Project Name: Canal Plaza Hotel – Plan Amendments
Address: 433 Fore Street
Applicant: Cow Plaza Hotel, LLC, Applicant
Planner: Nell Donaldson

Project ID: 2013-089
CBL: 32-I-42

Helen Donaldson - RE: Light pole bases on Fore St

TO: Tim Hart, AIA
FROM: Megan McDevitt, PE
CC: Scott Hawk, PE and Denise Cameron, PE
DATE: November 12, 2013
RE: Light Pole Foundations for Street Lights at Hyatt Place, on Fore Street, Portland Maine

C-201

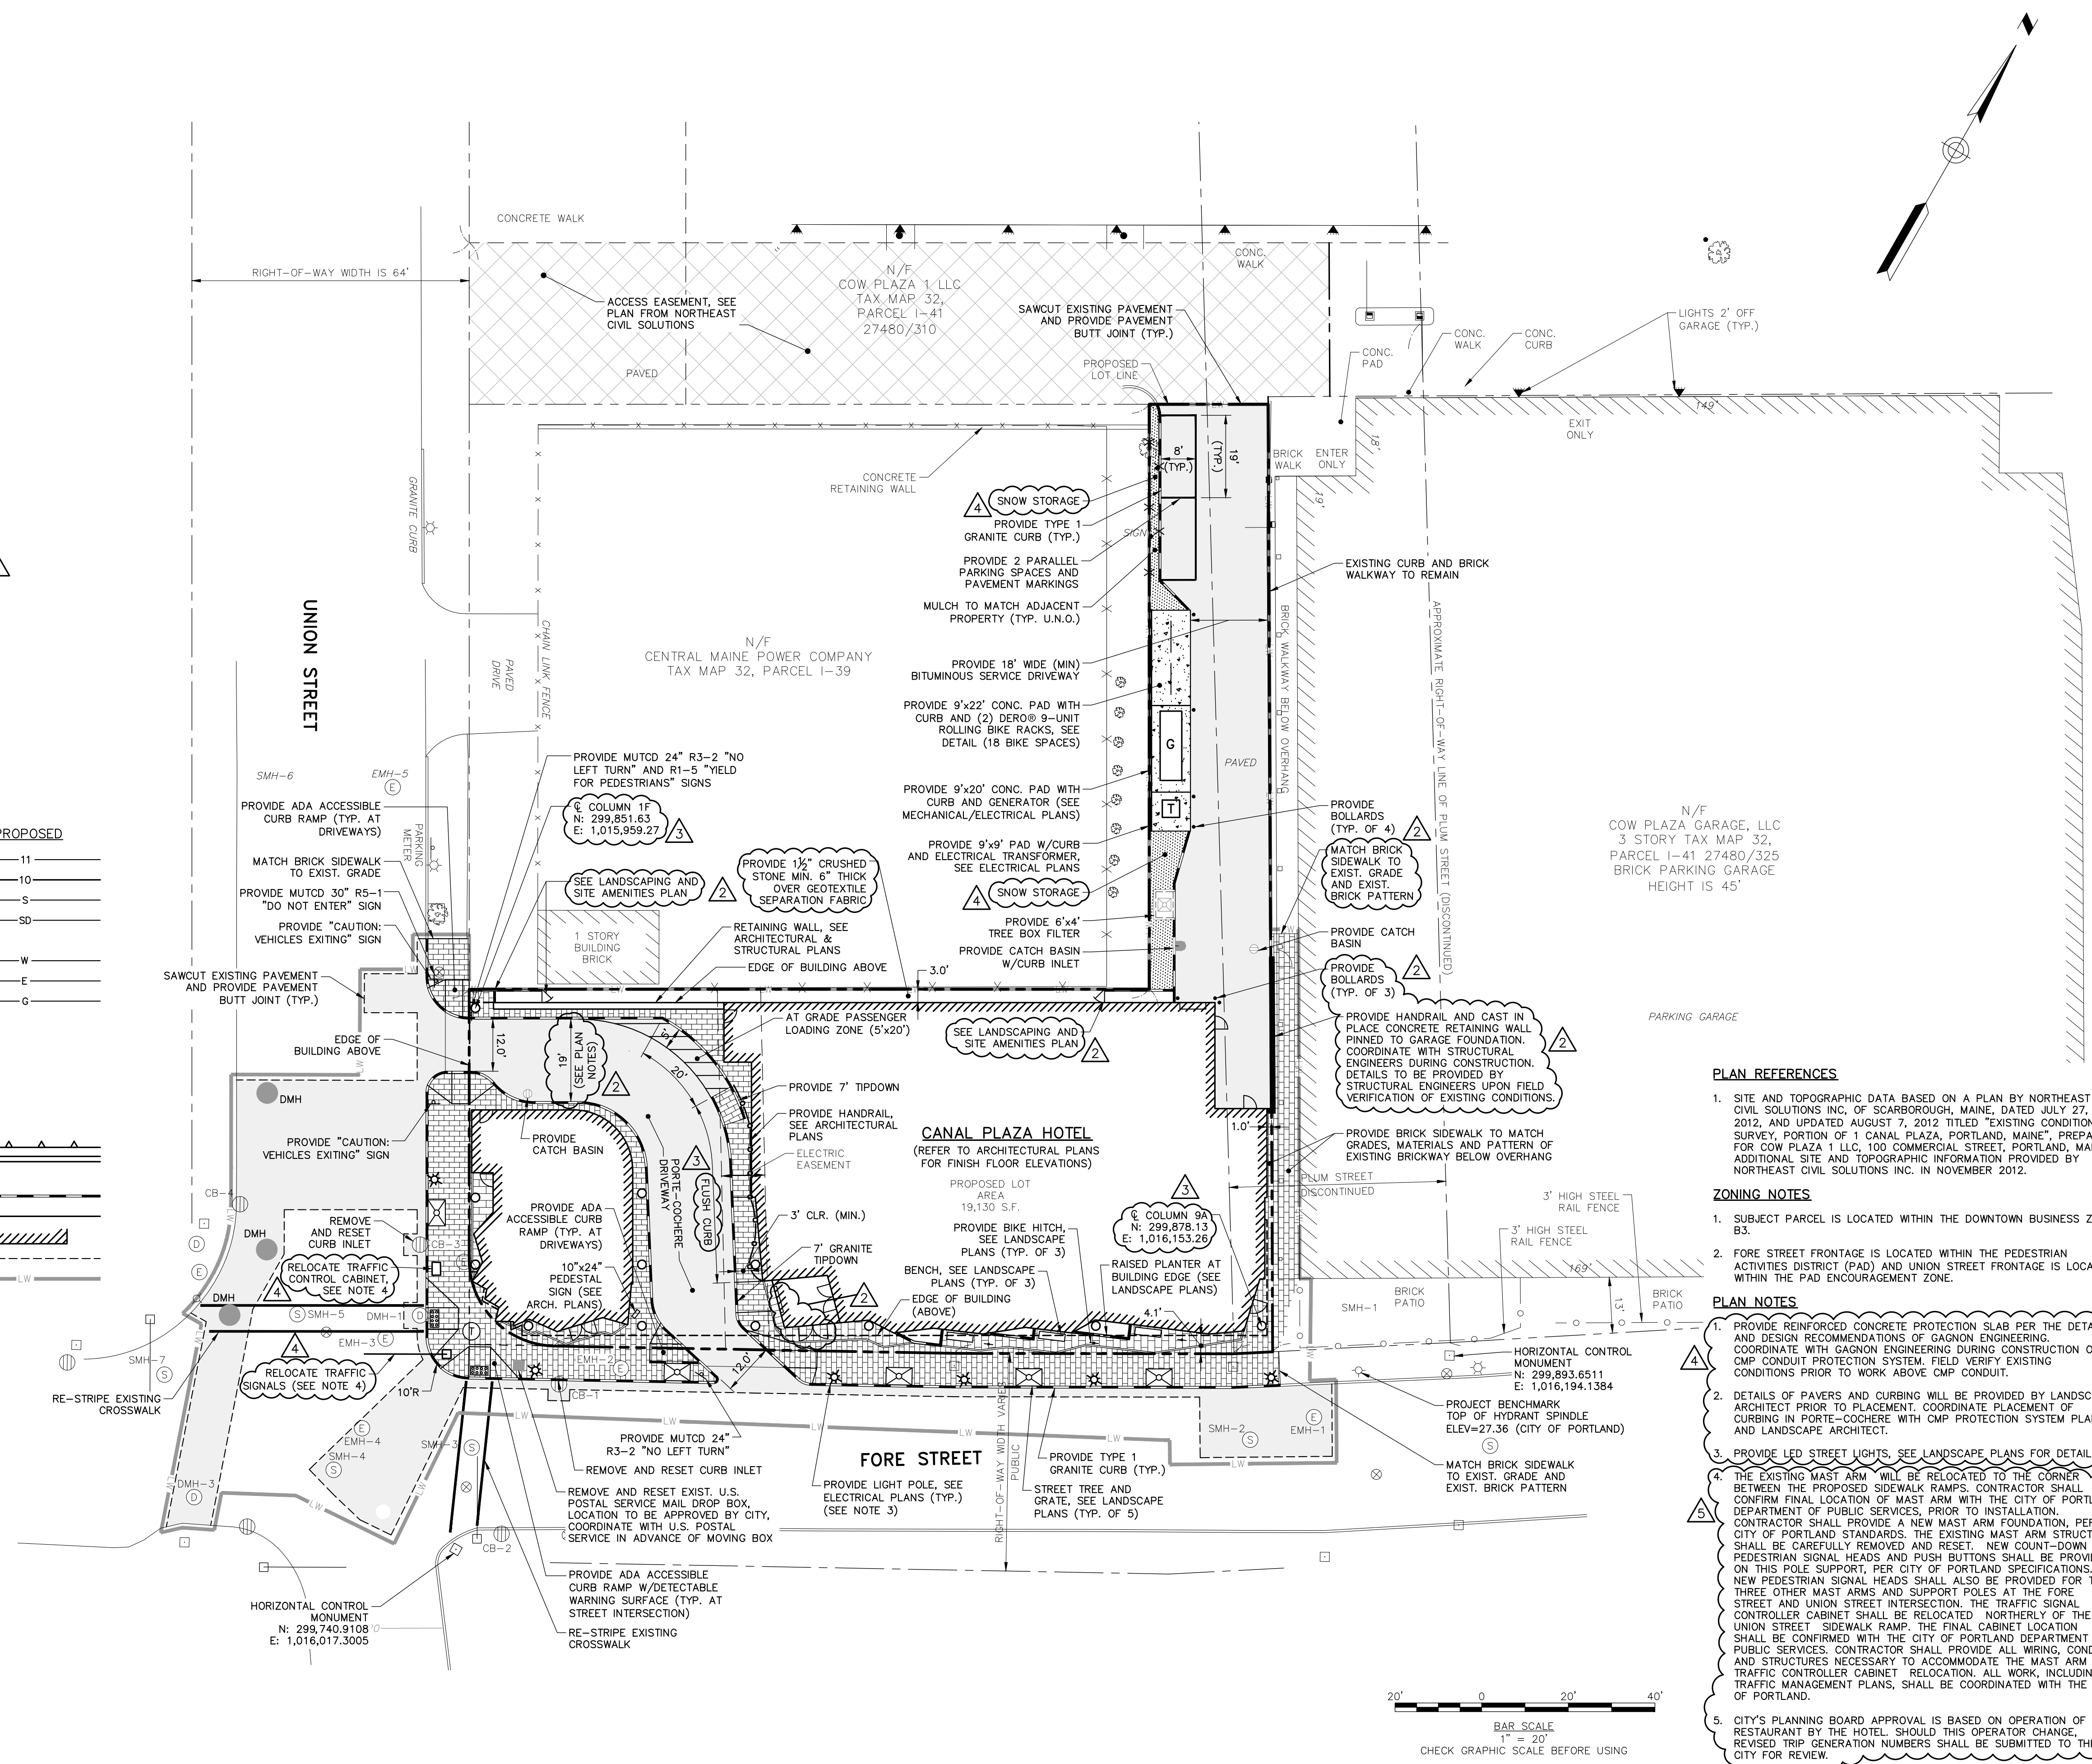
Public Services is agreeable with the proposed design. However it is critical that the contractor compact the soils under this spread footing for the light pole bases to facilitate weight distribution off the CMP conduit. In discussion with Micky Hall, the site foreman for Shaw Brothers Construction Company, the soils beside the conduit were never disturbed. This is ideal and we feel the risk to the CMP conduit is minimal.

Please proceed as proposed.
